August 27, 2025

Robert Webb & Jolene Wolfley
Development Facilitation Team
City of Albuquerque
Albuquerque, NM

**RE: Applications PR-2023-008710 & SI-2025-00082
U-Haul Site Plan Comments/Responses #2
8200 Jefferson St NE, Albuquerque, NM**

DRAWN:	GBV	C3-10
CHECKED:	ARA

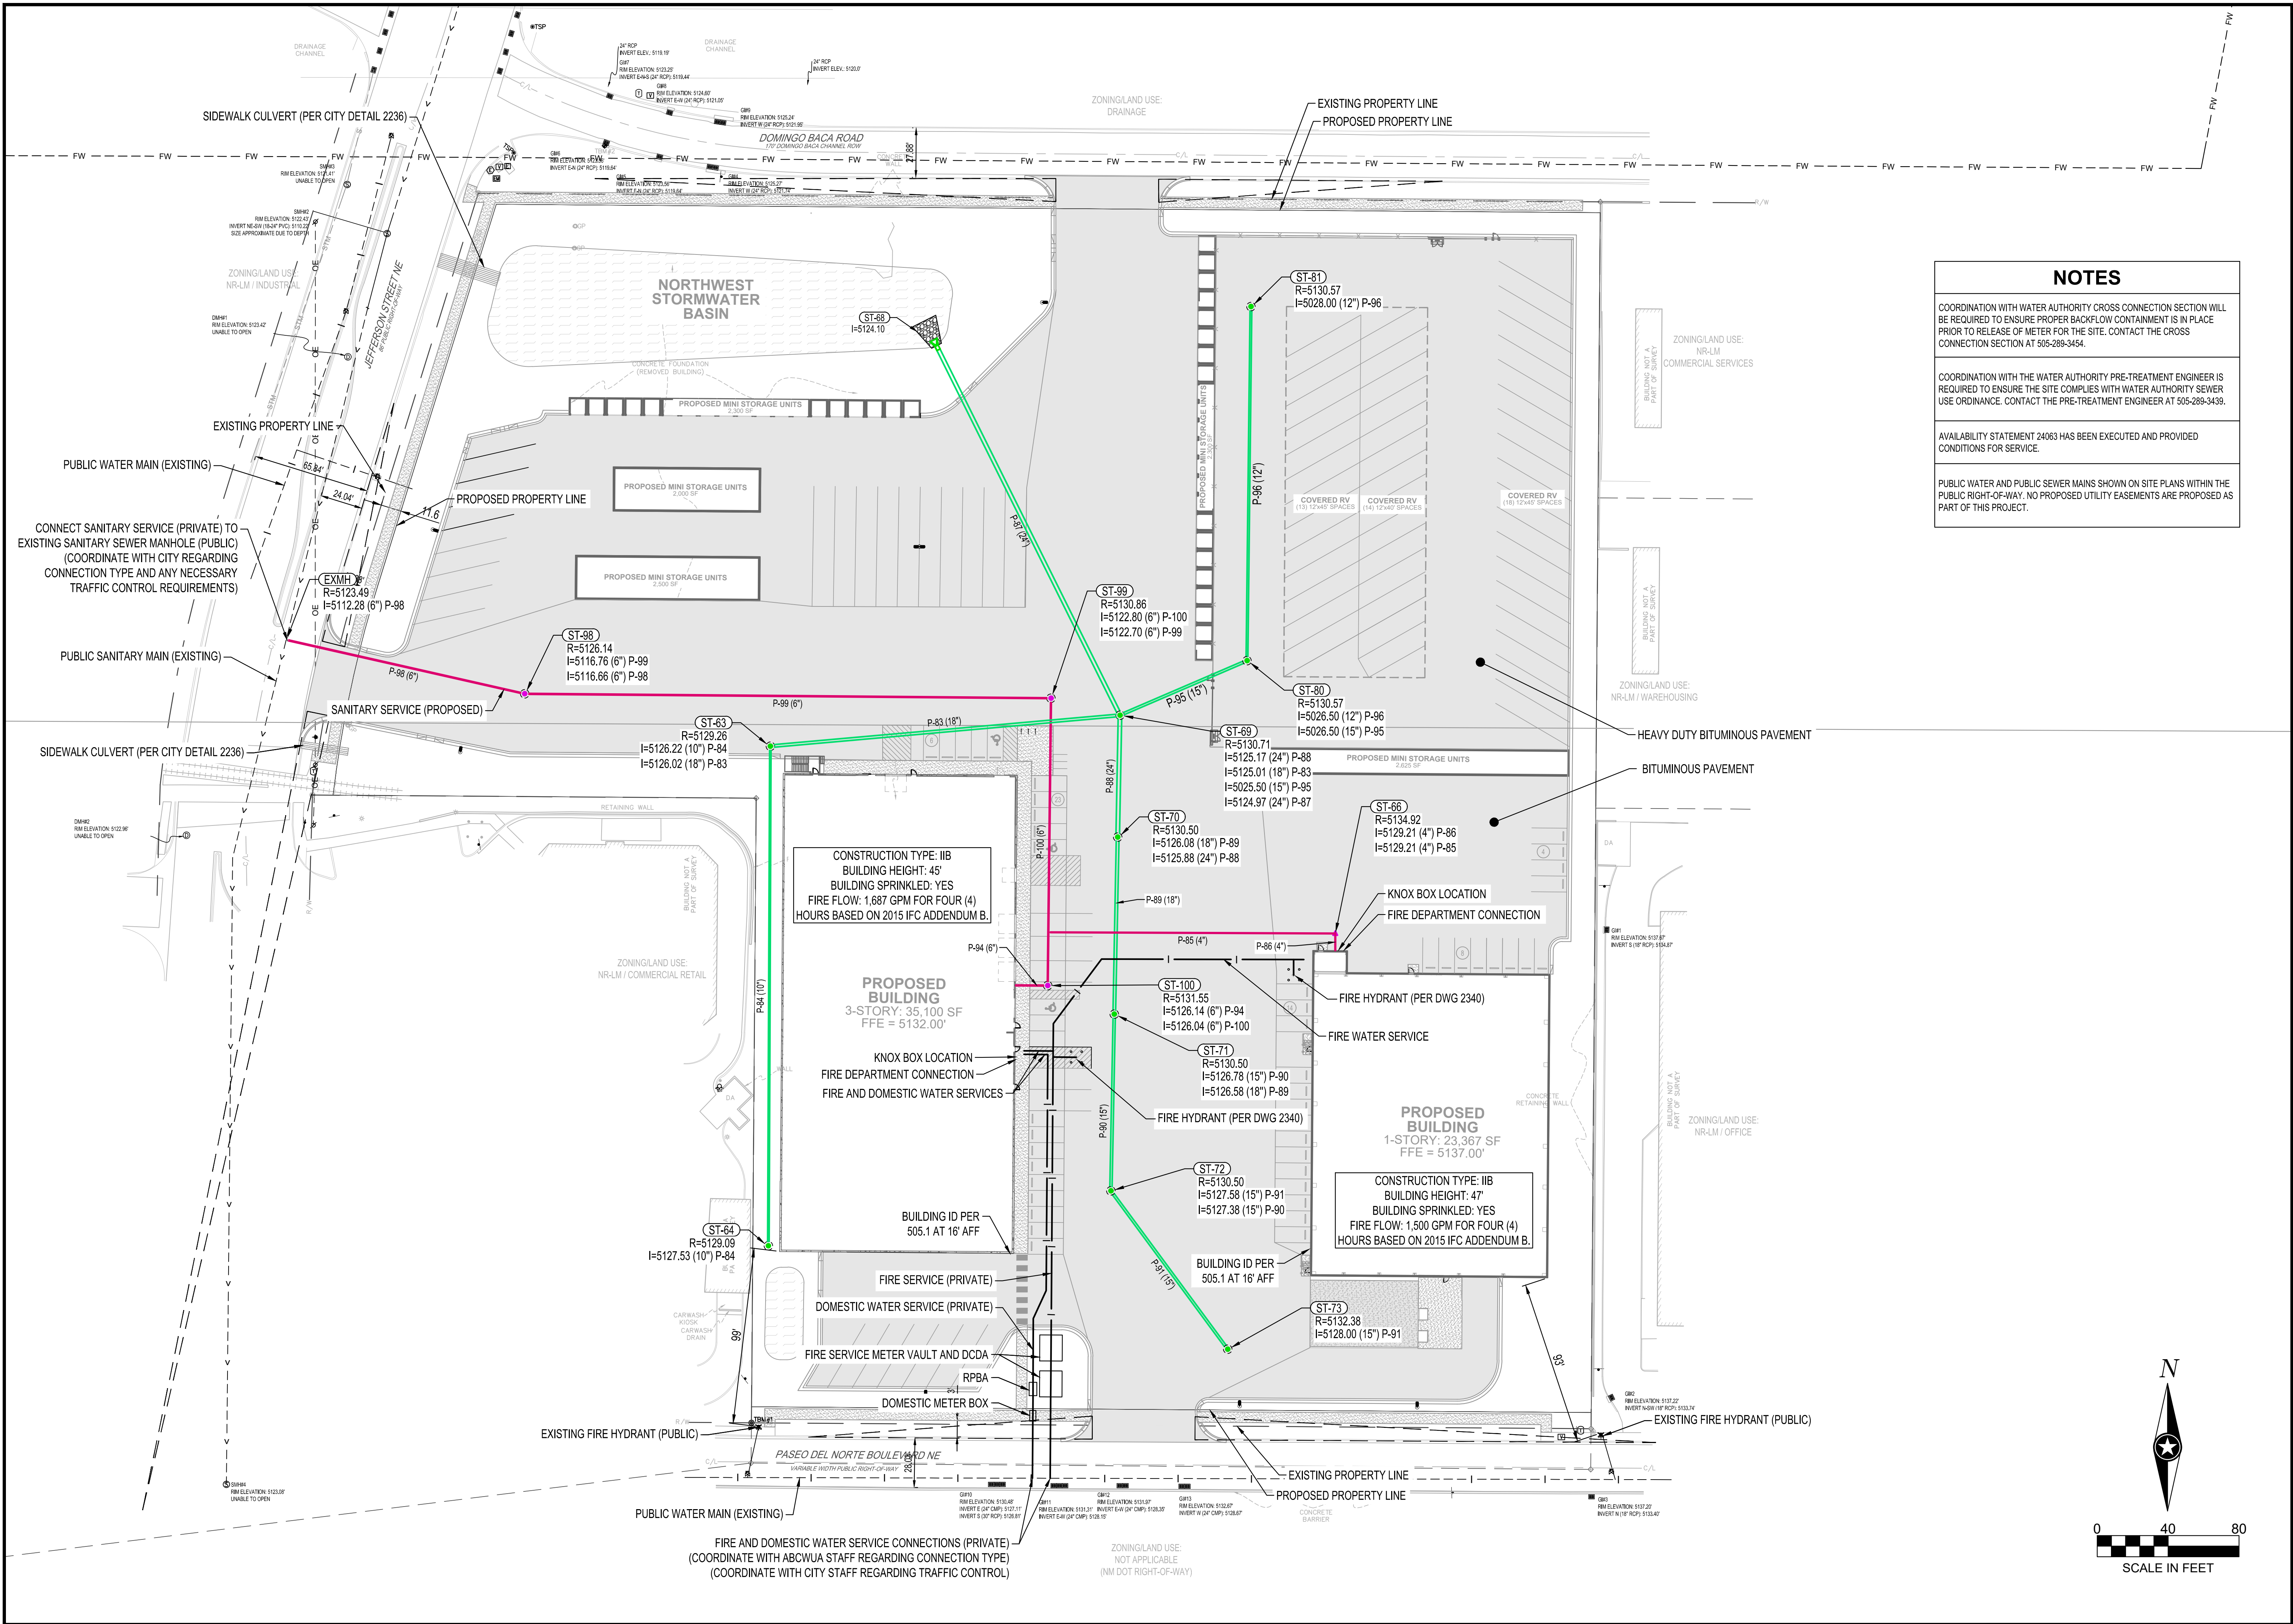
- 6. An outdoor seating area is required for a primary building(s) more than 30,000 s.f

ISG Response: This is located in the NE corner of the proposed 3-story building shown on Sheet C3-10.

DRAWN:	GBV	
CHECKED:	ARA	C3-21
DATE:

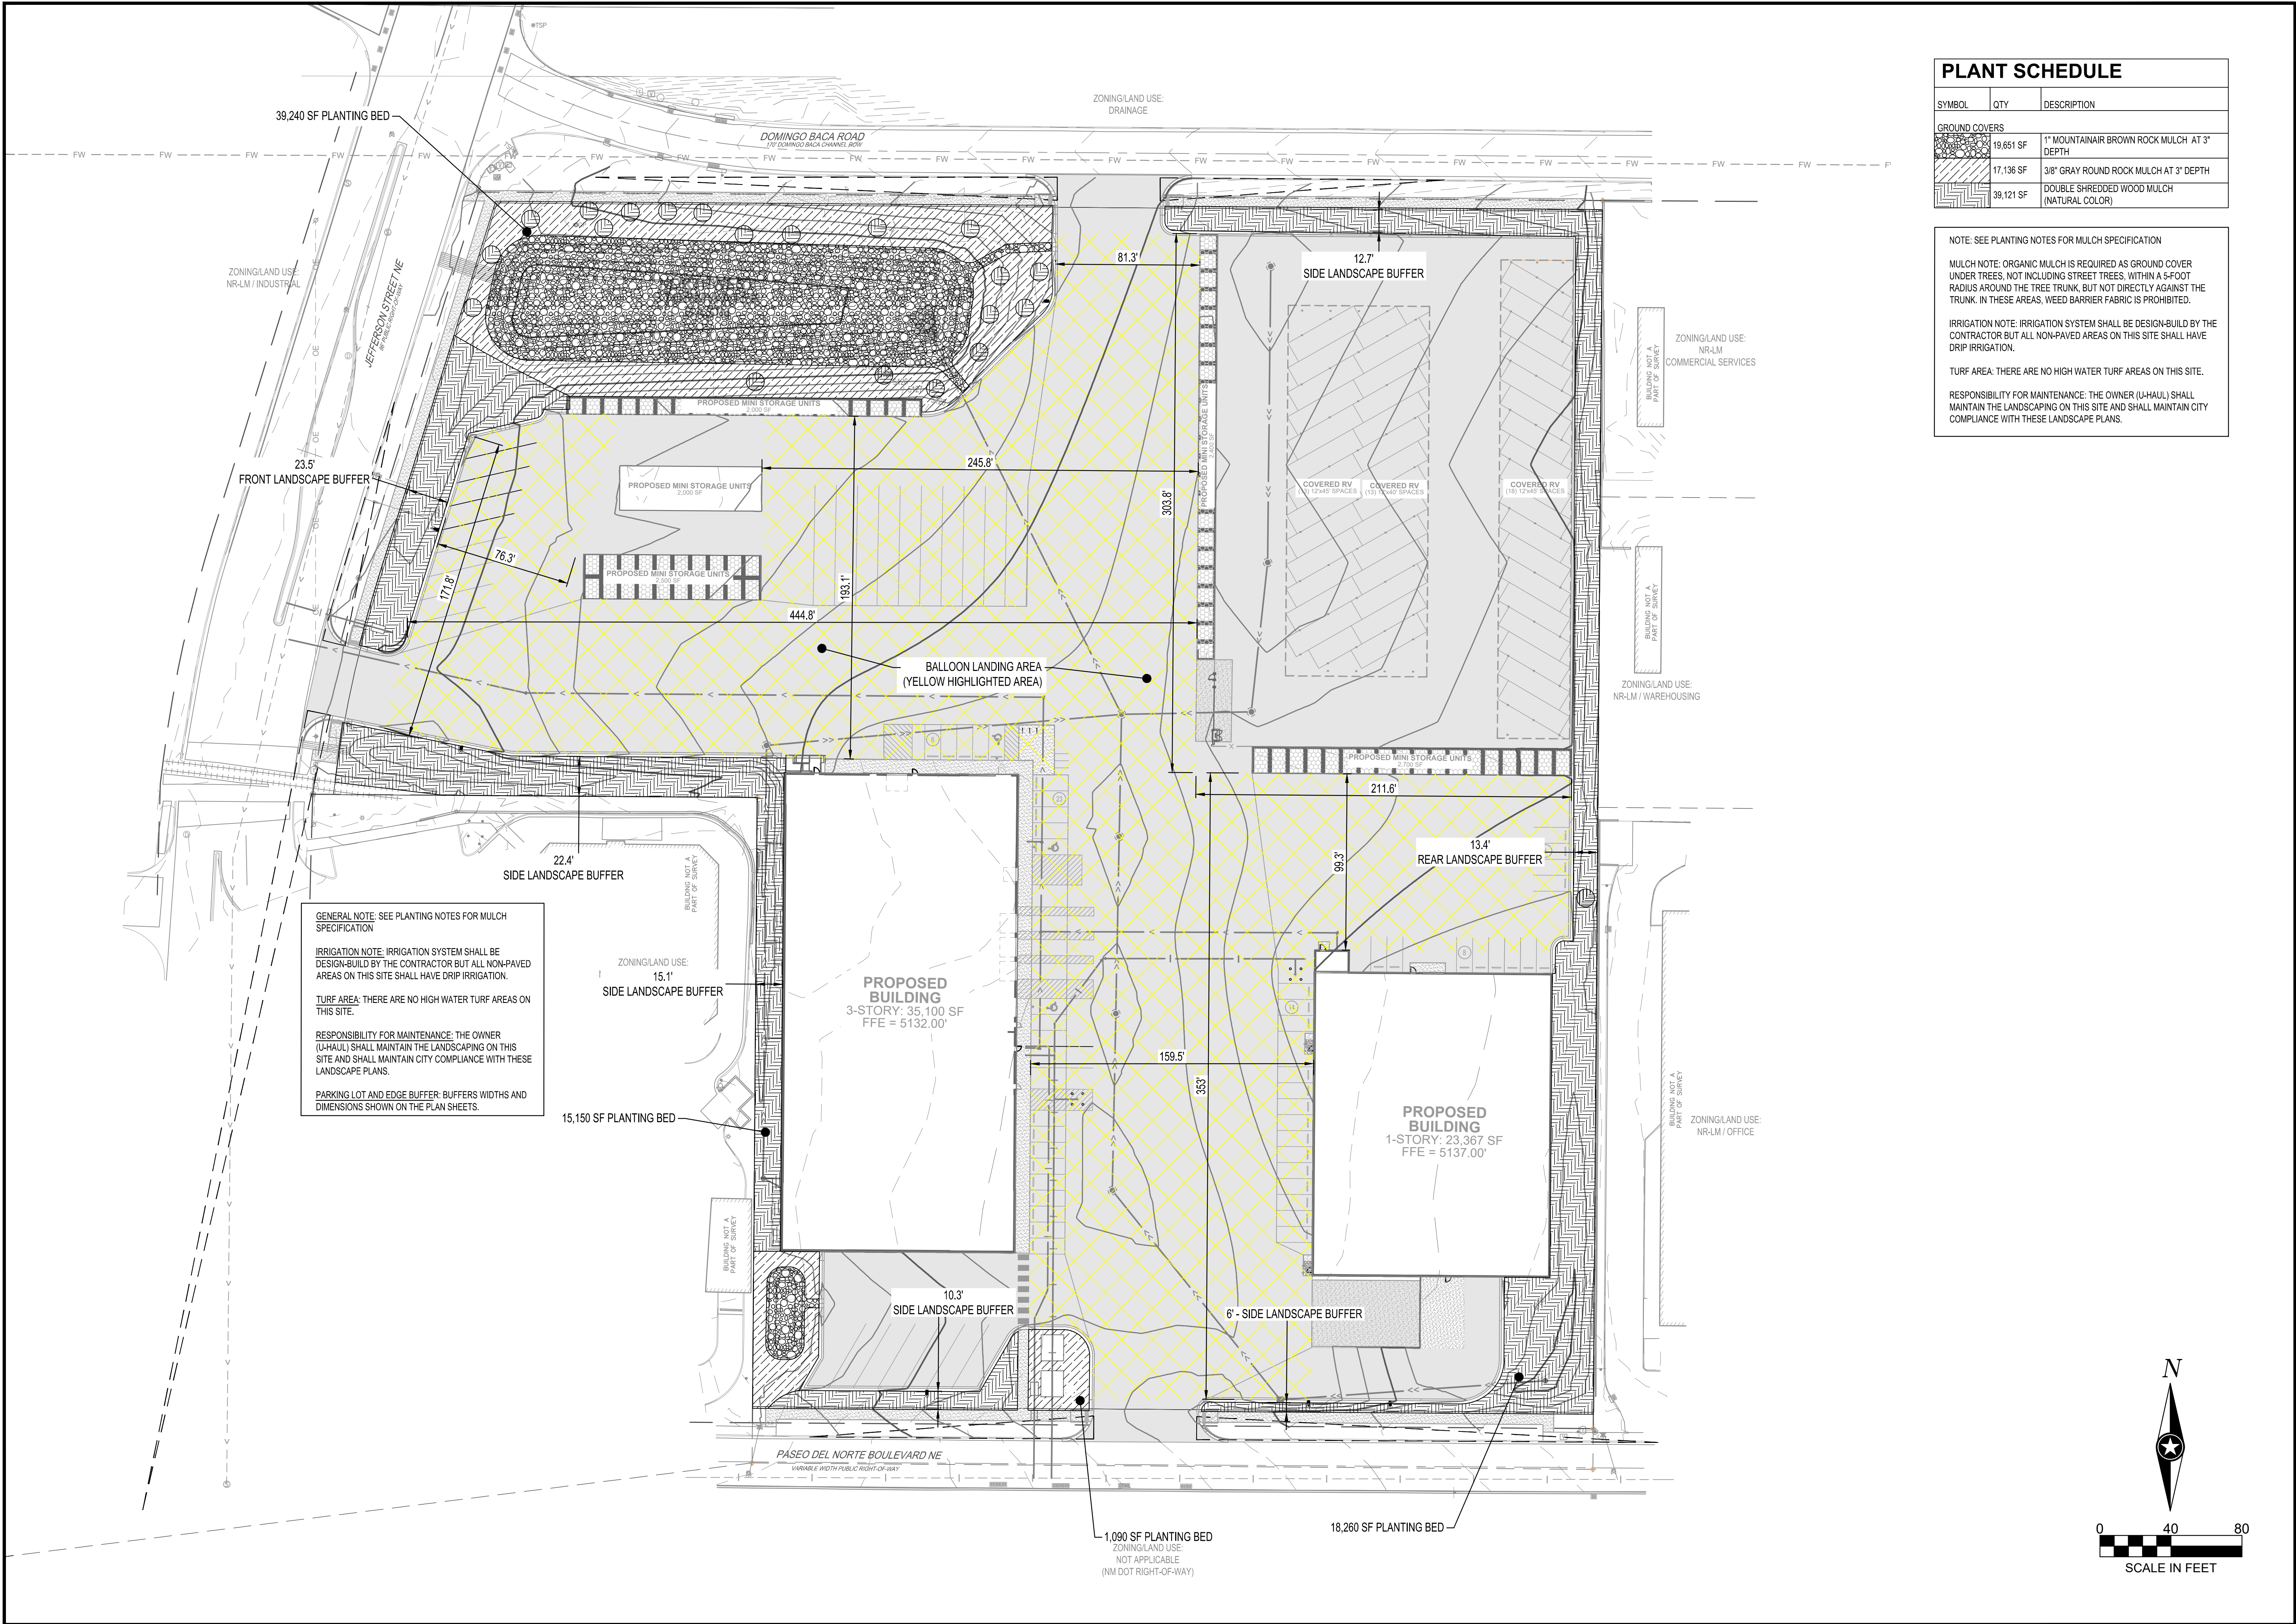
- a. As proposed, the meter box appears to be shown within the property. Please revise or provide an easement for the meter box.

- b. Please also make it clear at the connection point what is public. E.g. the infrastructure for water within right of way is public.

ISG Response: Proposed meter box is within the current private property but will be in the new public ROW once replatted to align with new city ROW. It will be in City ROW.

ISG Response: Proposed site plan label and linework shown on the plans.
